DEVELOPMENT REVIEW BOARD
TRANSPORTATION DEVELOPMENT

DRB Project Number: 1011471
Mcleod Business Park

SUBJECT: Sketch Plat

DATE: April 4, 2018

**Plat for
Tracts 2-A-3-C-1 & 2-A-3-C-2
McLeod Business Park
Being Comprised of
Tracts 2-A-3-C and 2-A-3-D
McLeod Business Park
City of Albuquerque
Bernalillo County, New Mexico
March 2018**

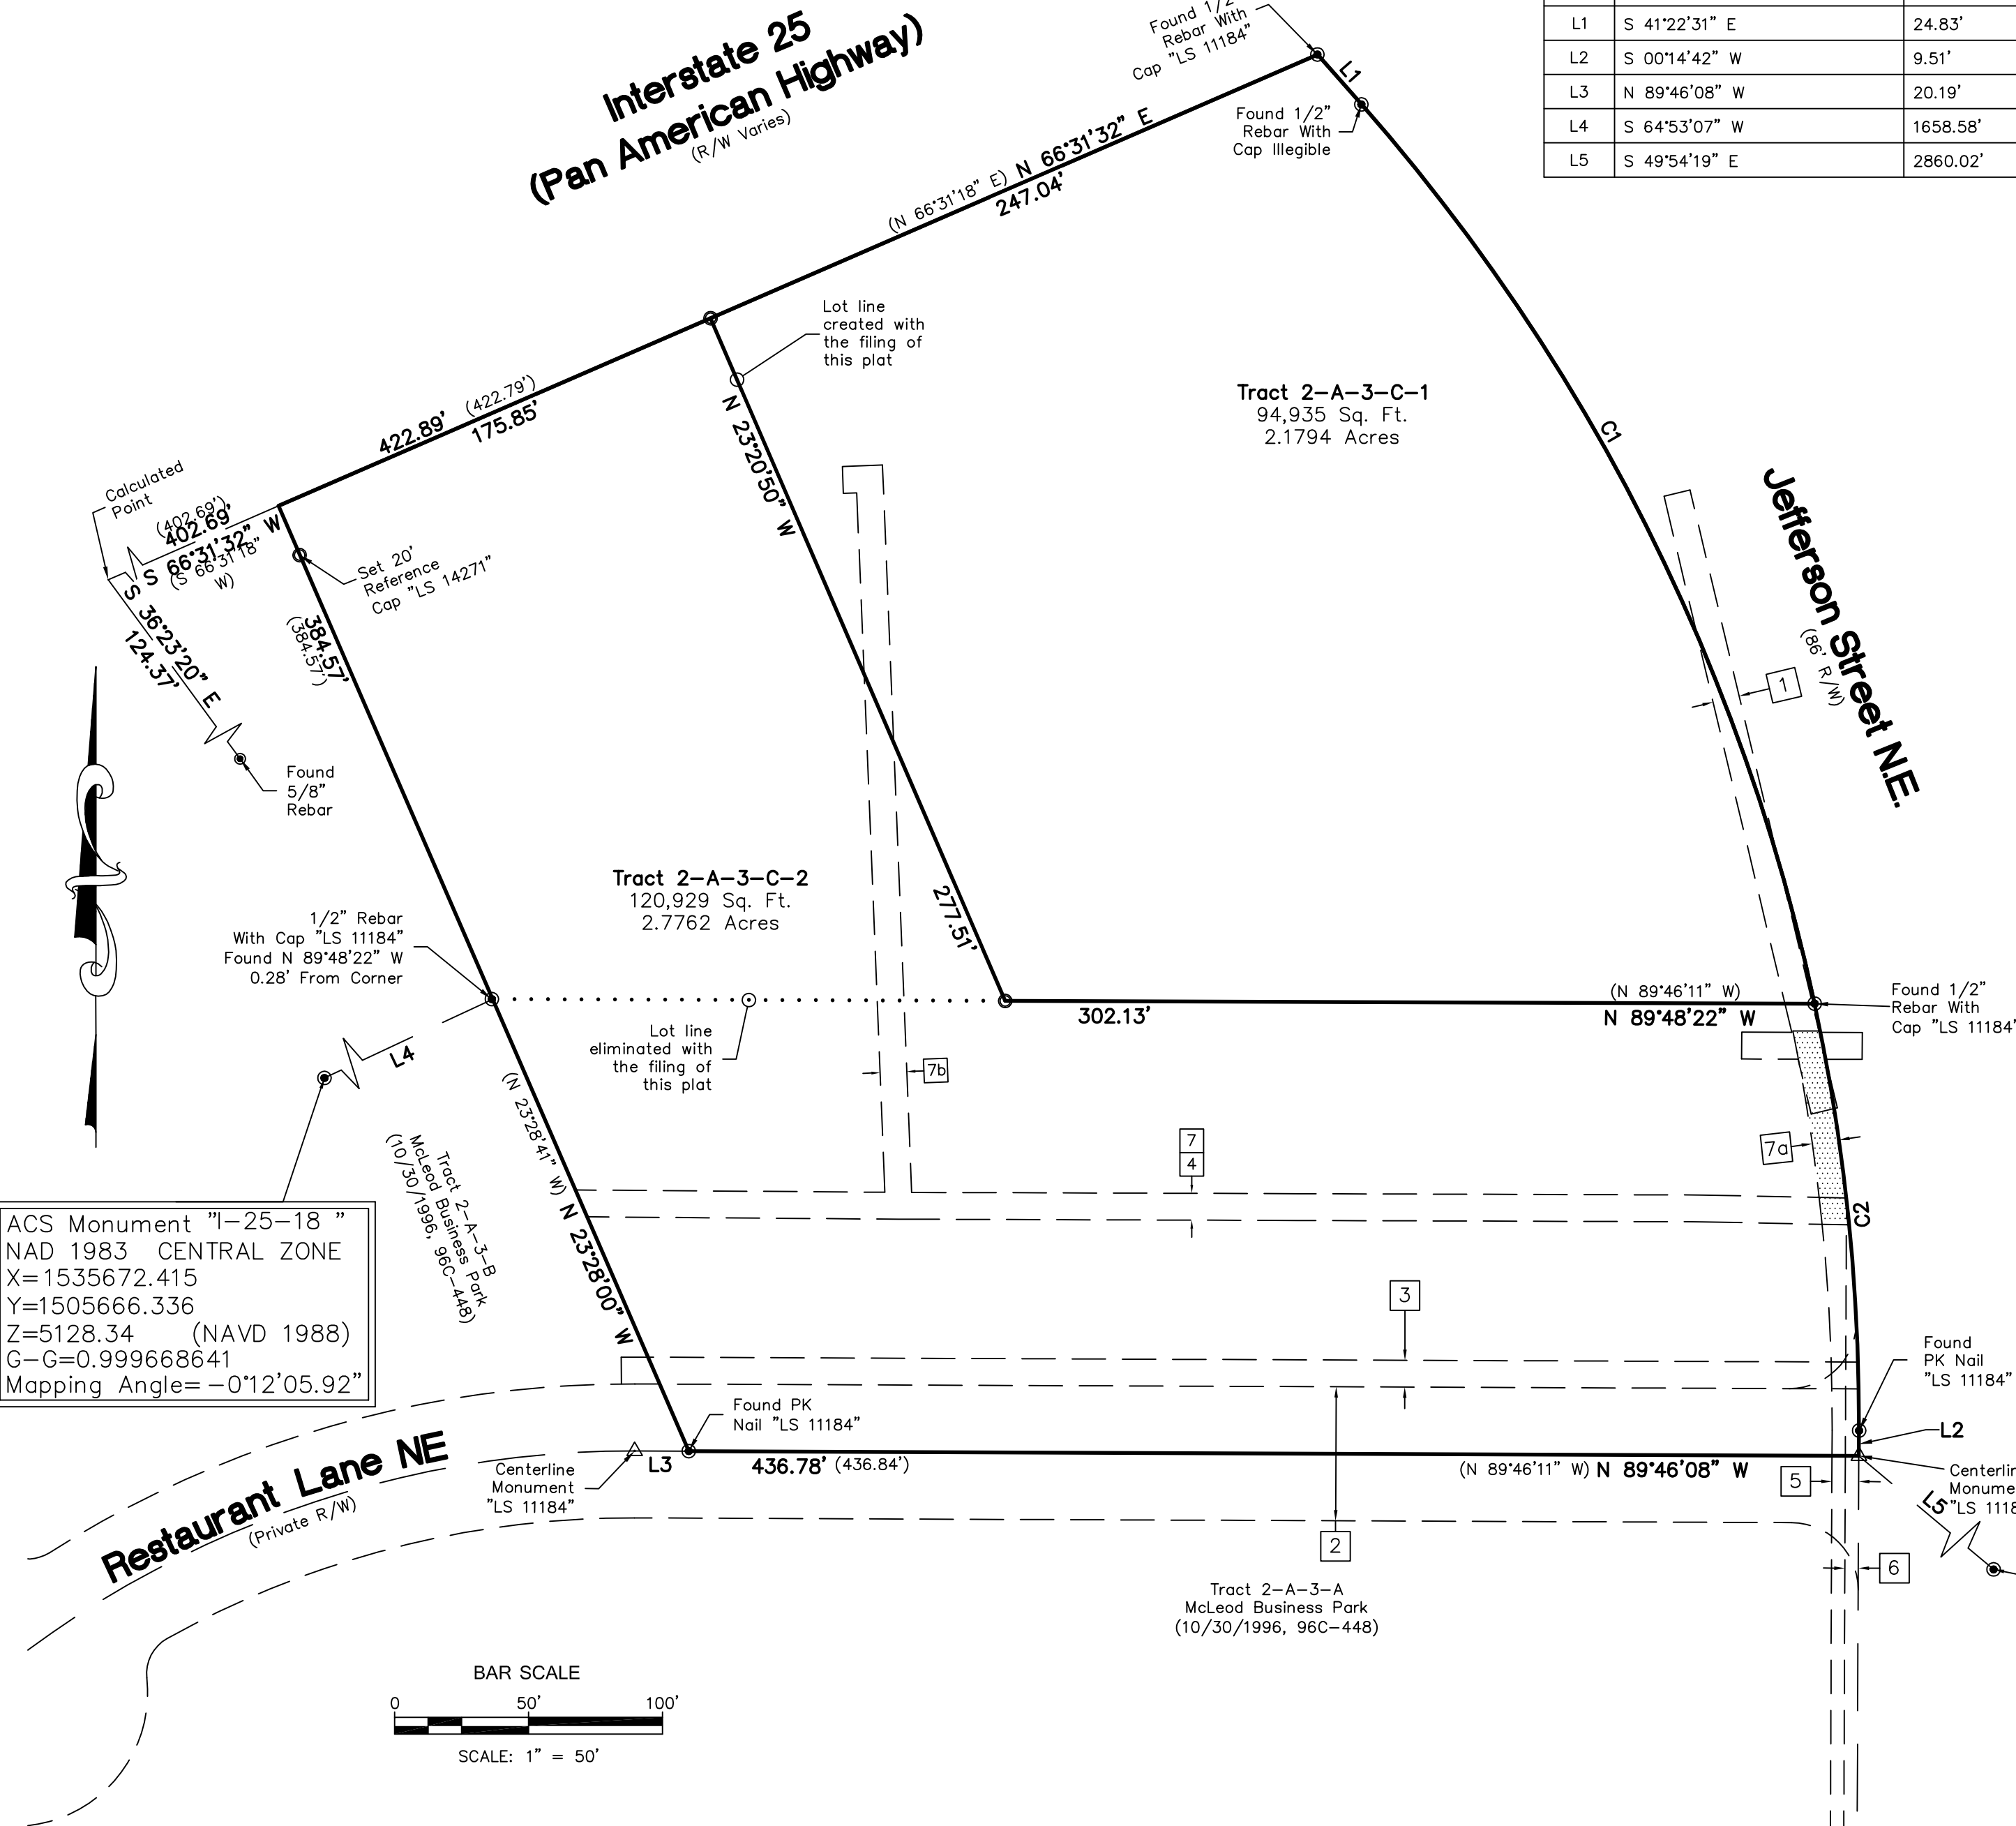
1. Provide a shared access and parking easement between the lots.
2. For final plat, any access easements need to be shown with all beneficiaries and maintenance responsibilities listed.
3. If future development is not going to be submitted to DRB, a TCL (Traffic Circulation Layout) will be required before building permit.
